CITY OF PORTLAND BUILDING PERMIT

142 SHERIDAN ST

PERMIT ID: 2013-00734

has permission to **400 sq ft above garage renovation to master bedroom and bath. No change to sq ft.** provided that the person or persons, firm or corporation accepting this permit shall comply with all of the provisions of the Statues of Maine and of the Ordinances of the City of Portland regulating the construction, maintenance and use of the buildings and structures, and of the application on file in the department.

**Proposed Garage Renovation  
142 Sheridan St.**

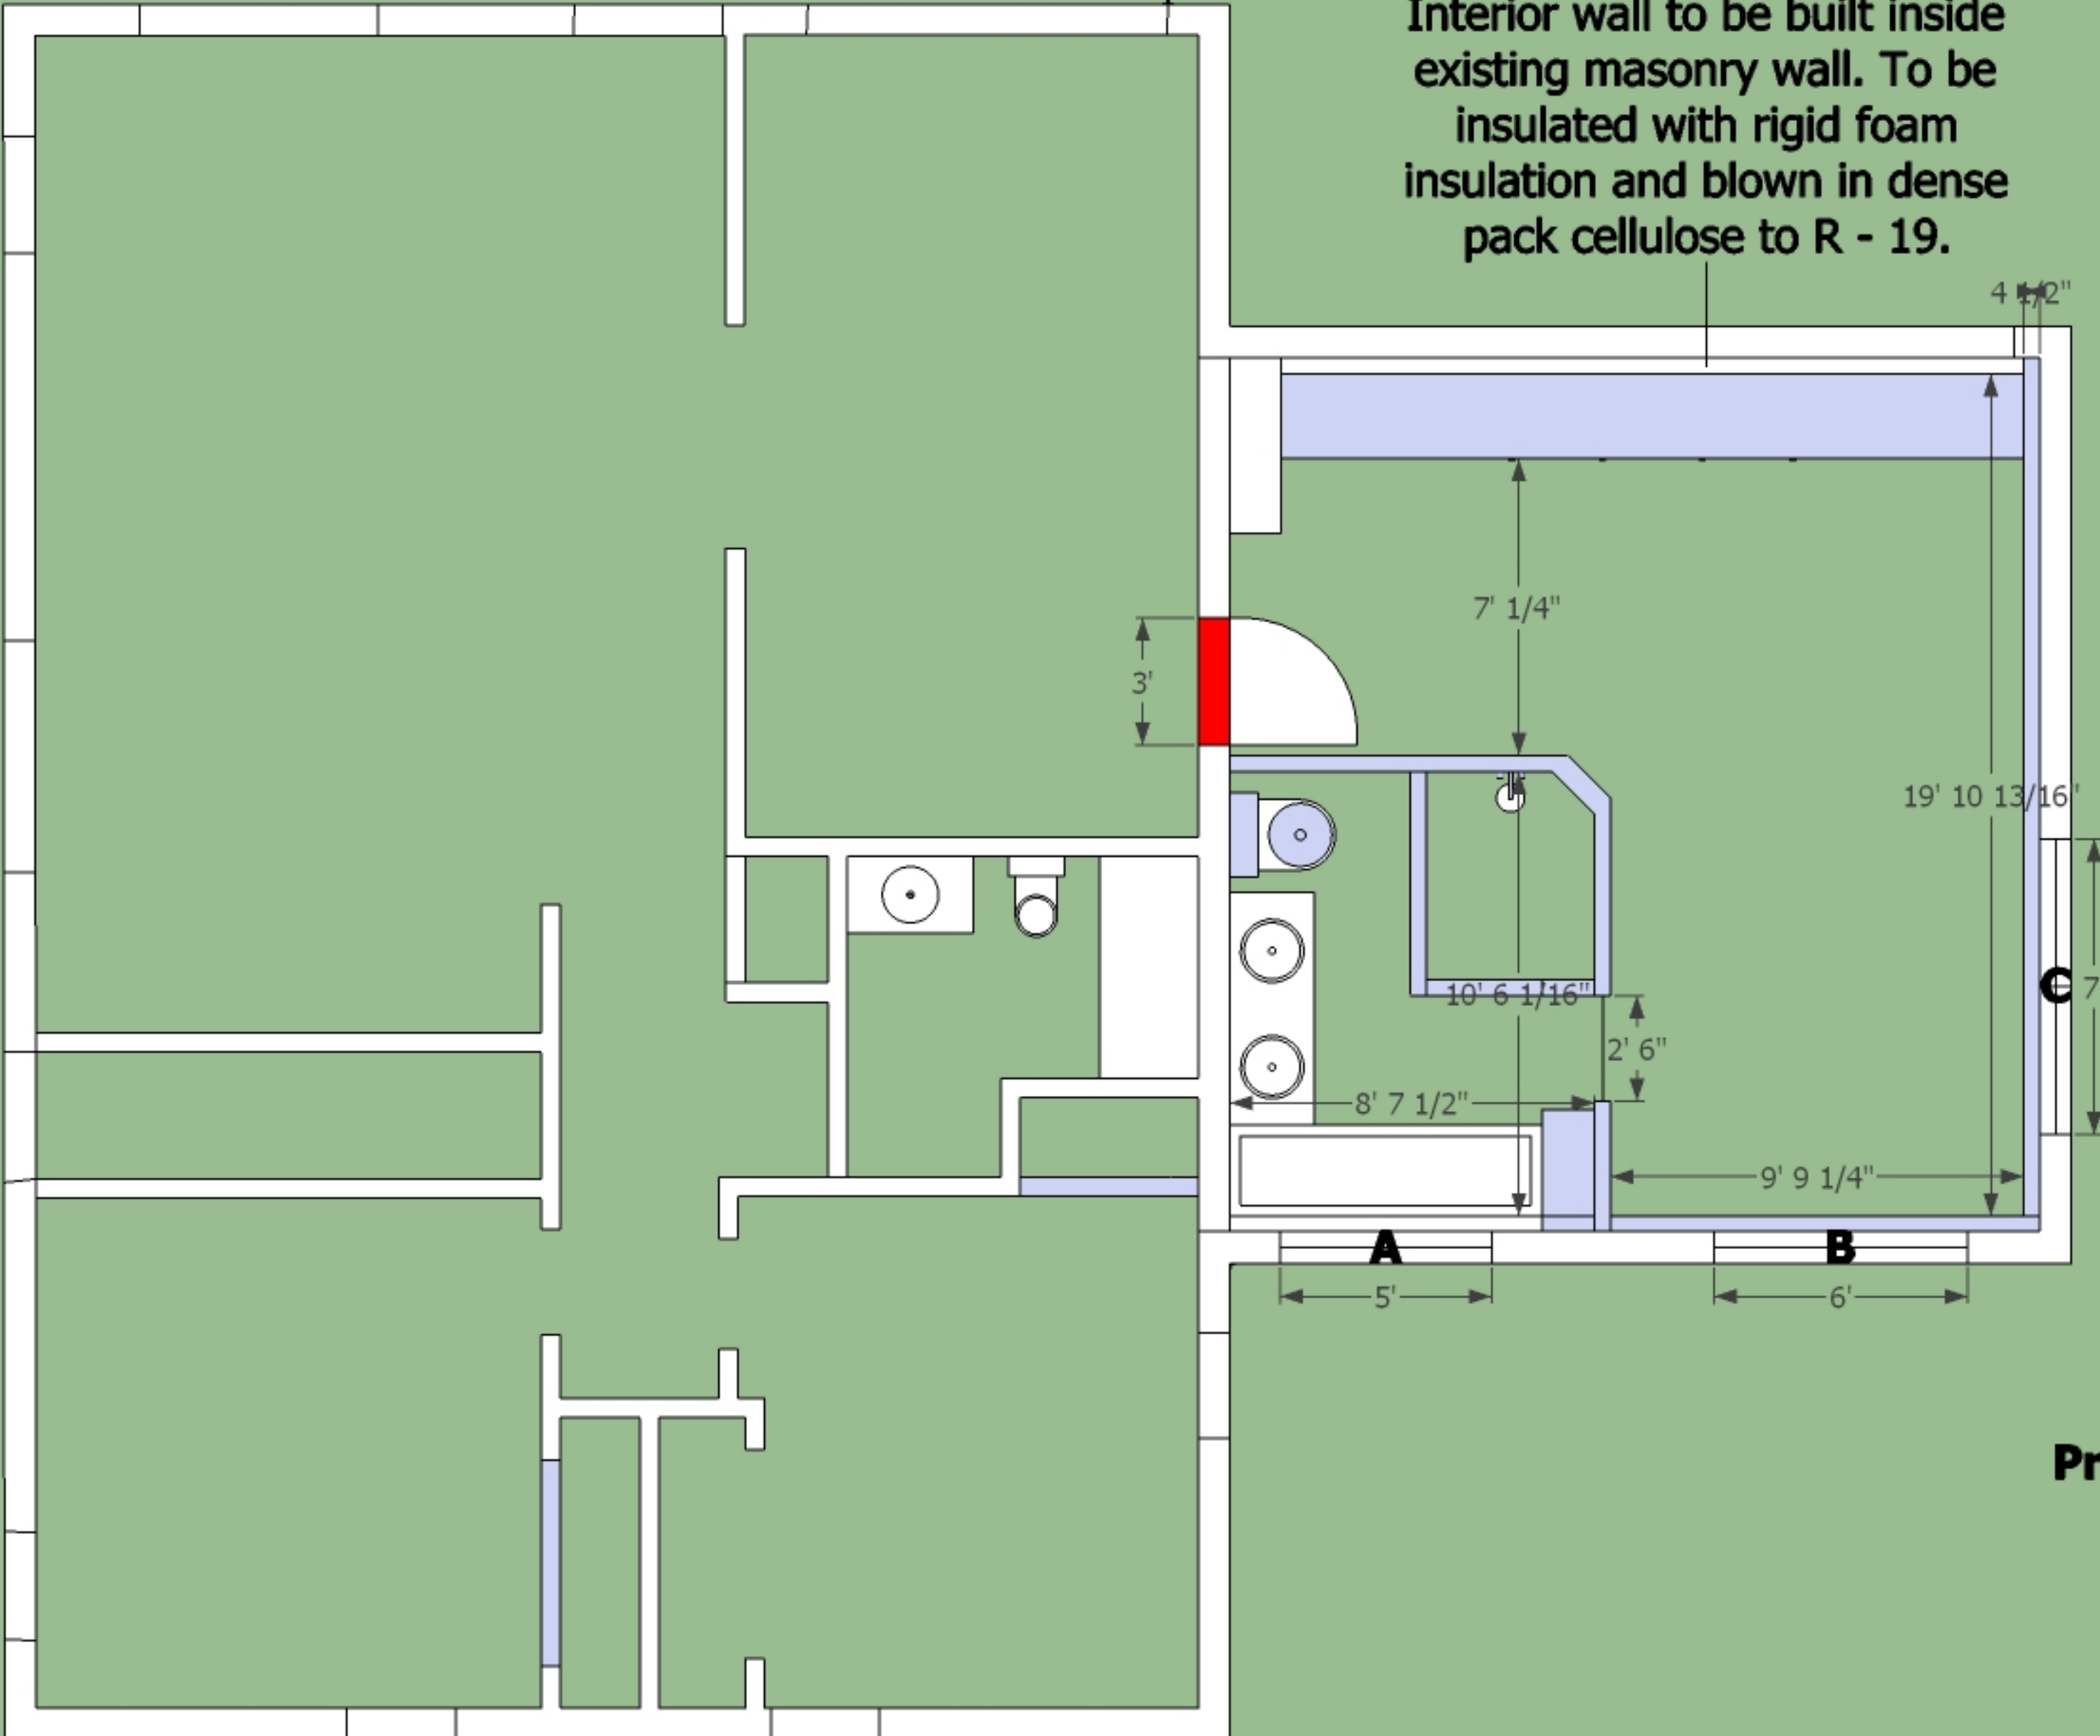
5) R612.2 Window sills. In dwelling units, where the opening of an operable window is located more than 72 inches above the finished grade or surface below, the lowest part of the clear opening of the window shall be a minimum of 24 inches above the finished floor of the room in which the window is located. Operable sections of windows shall not permit openings that allow passage of a 4 inch diameter sphere where such openings are located within 24 inches of the finished floor. A code compliant emergency escape shall be provided in the proposed bedroom. Window sills in locations more than 72 inches from finished grade shall be a minimum of 24 inches (no higher than 44 inches) above the finished floor of the room, or in compliance with Section R612.4.2

Wall Framing Detail Proposed

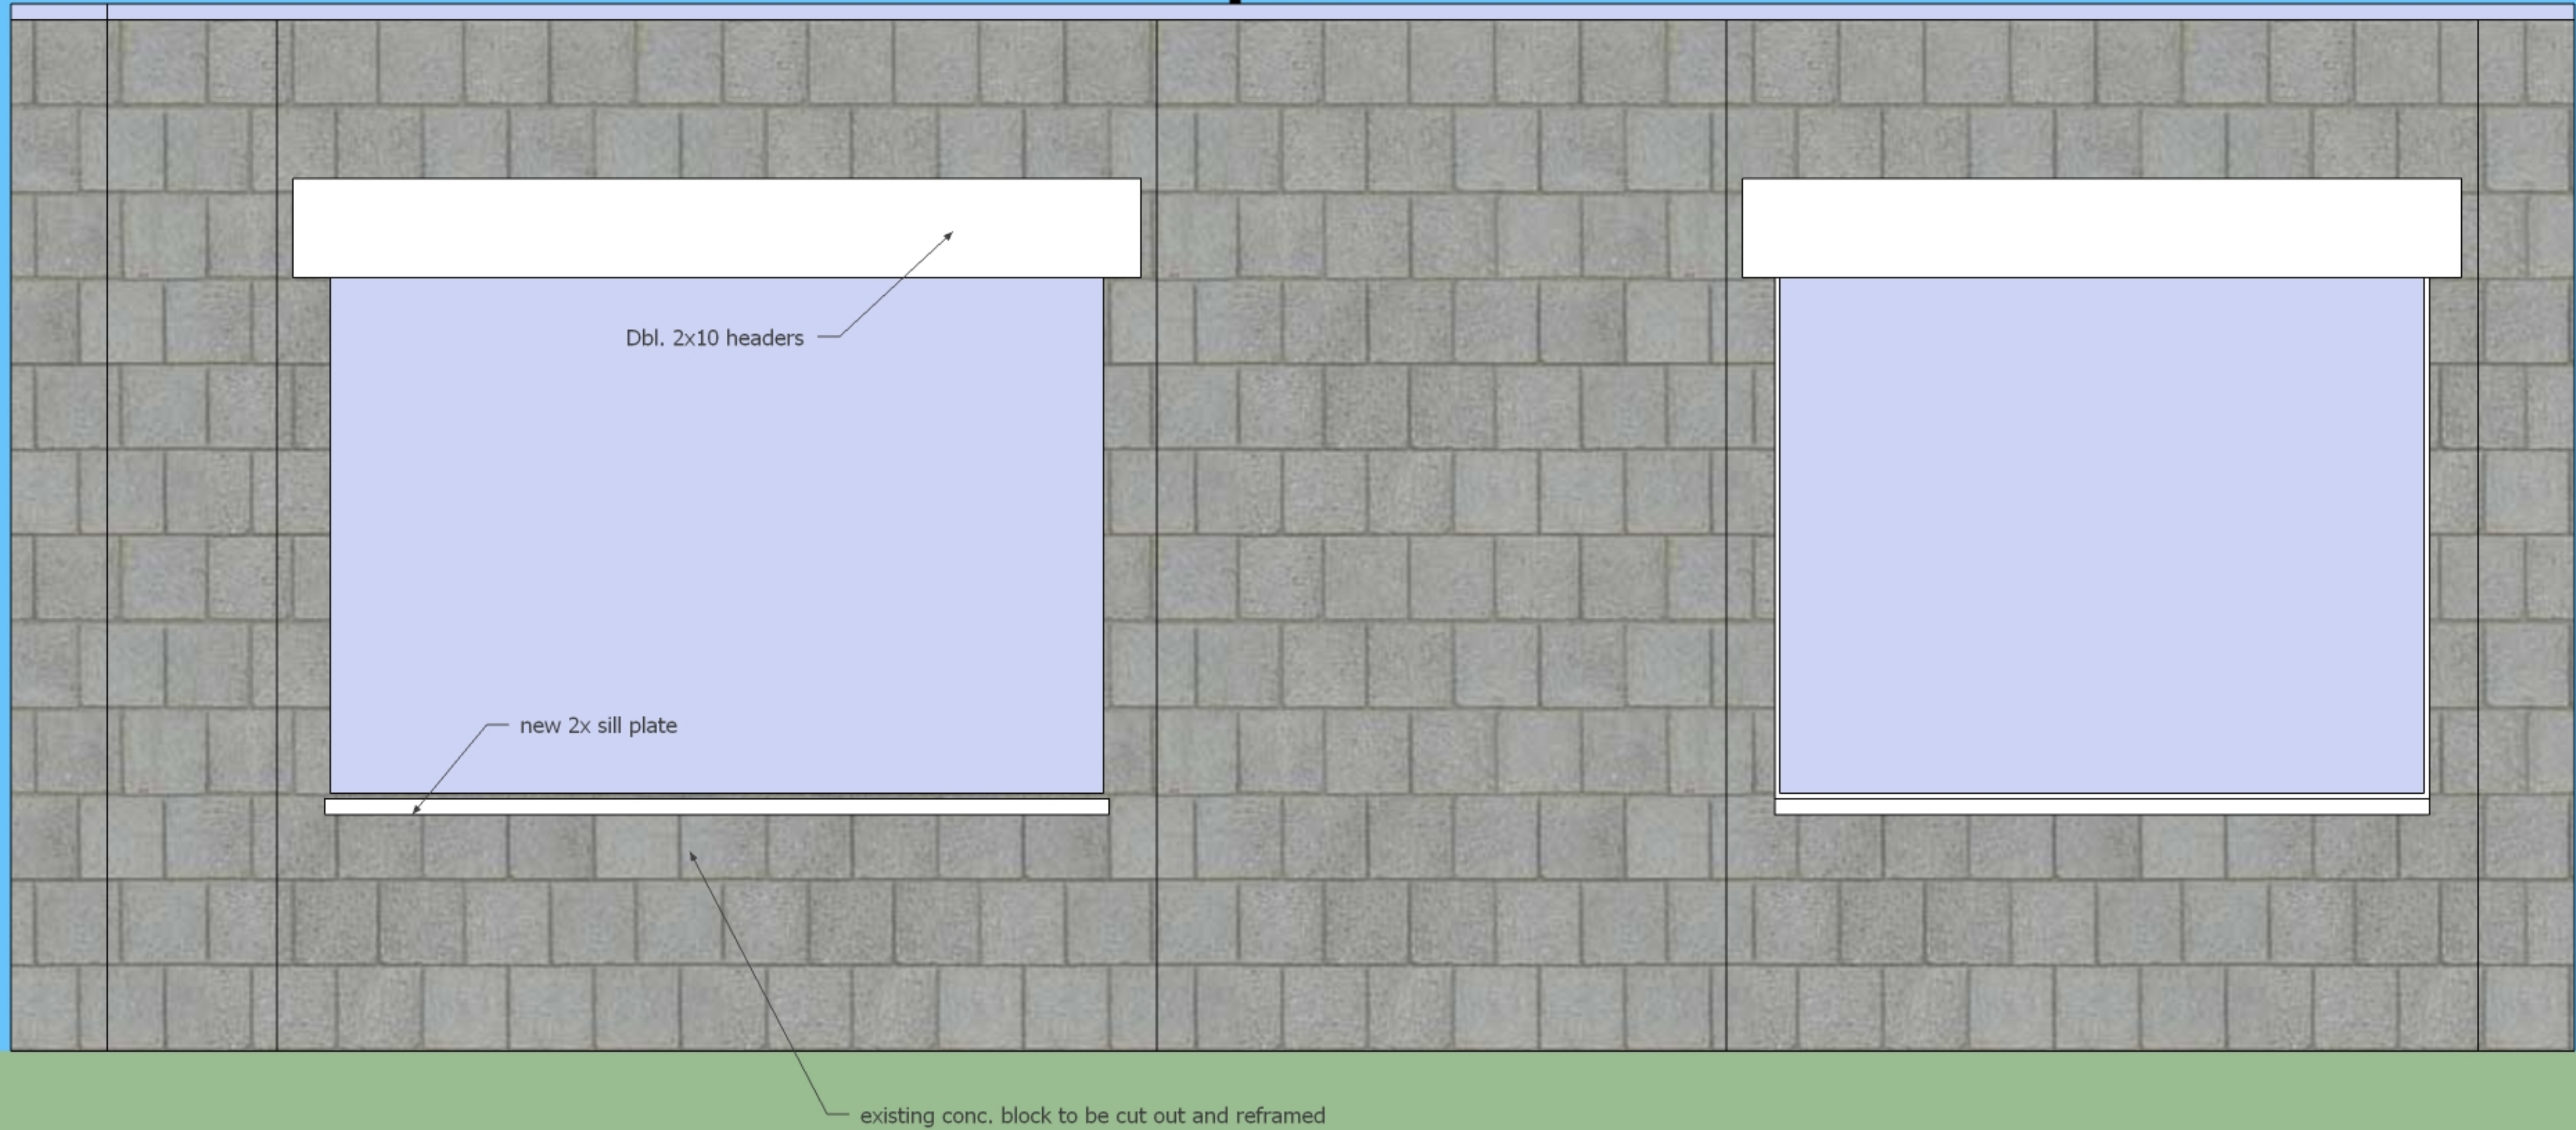
1) Submit specification for the engineered structural ridge. Roof Rafter framing and Connection shall comply with Section R802.3 & R802.3.1 of MUBEC. R502.6 Bearing. The ends of each joist, beam or girder shall have not less than 1.5 inches of bearing on wood or metal and not less than 3 inches on masonry or concrete except where supported on a 1-inch-by-4-inch ribbon strip and nailed to the adjacent stud or by the use of approved joist hangers.
